Office of
Environment
& Heritage

Request for comments – Exhibition of Sydney Metro City and Southwest – Sydenham to Bankstown (SSI 8256)

Attachment 1 - Office of Environment and Heritage comments for the Sydney Metro City and Southwest – Sydenham to Bankstown (SSI 8256)

OEH has reviewed the Technical Paper 8 – Hydrology, flooding and Water Quality Assessment (GHD, September August 2017). OEH’s comments are generally confined to the methodology outlined in the report. From OEH’s perspective, the assessment prepared by GHD appears to follow accepted floodplain risk management practice. The assessment applies two modelling techniques, for Marrickville Station and for the rest of the project area between Dulwich Hill and Bankstown Station.

Figure 6-1

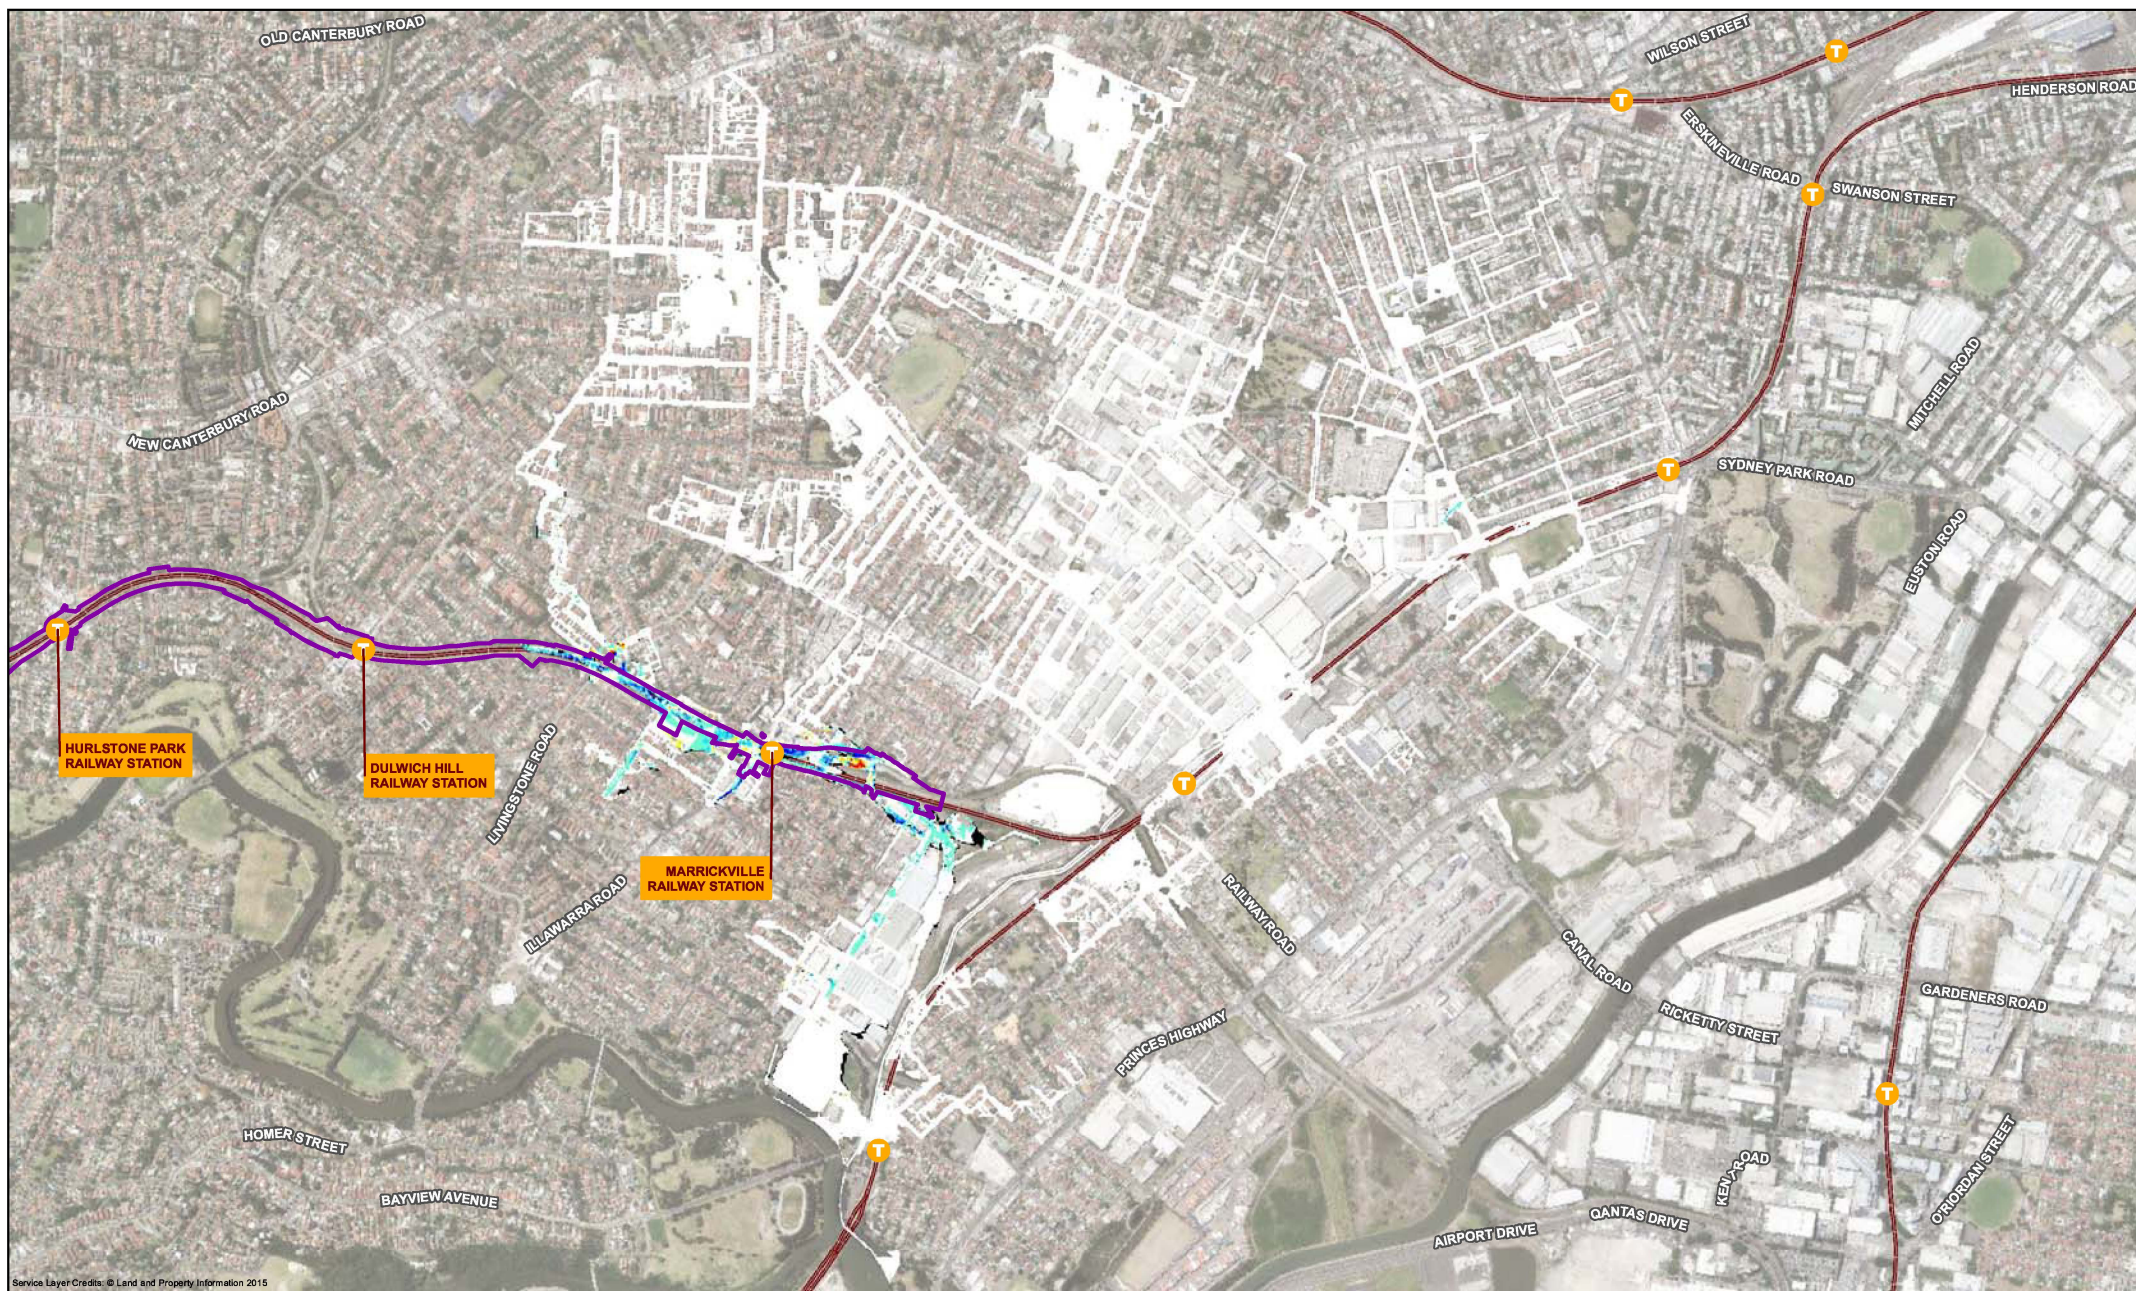
- The consultant utilises the information from existing flood studies and background information as stated in Section 3.6.1 to establish hydraulic TUFLOW 2D model in the vicinity of Marrickville Station. The model identifies existing and post-developed flooding characteristics for a range of flooding up to the probable maximum flood (PMF) as outlined in Table 2-1.
- Existing flooding conditions within the project area are outlined in Section 3.6.4. Appendix B of the report illustrates Flood Mapping for existing and post-developed scenarios including extent, depth, velocity, provisional hazard, climate change scenario equivalent to 1% AEP plus 10% increase in rainfall intensities and the impacts of the project on flood level and velocity for a range of the flood events up to the PMF.
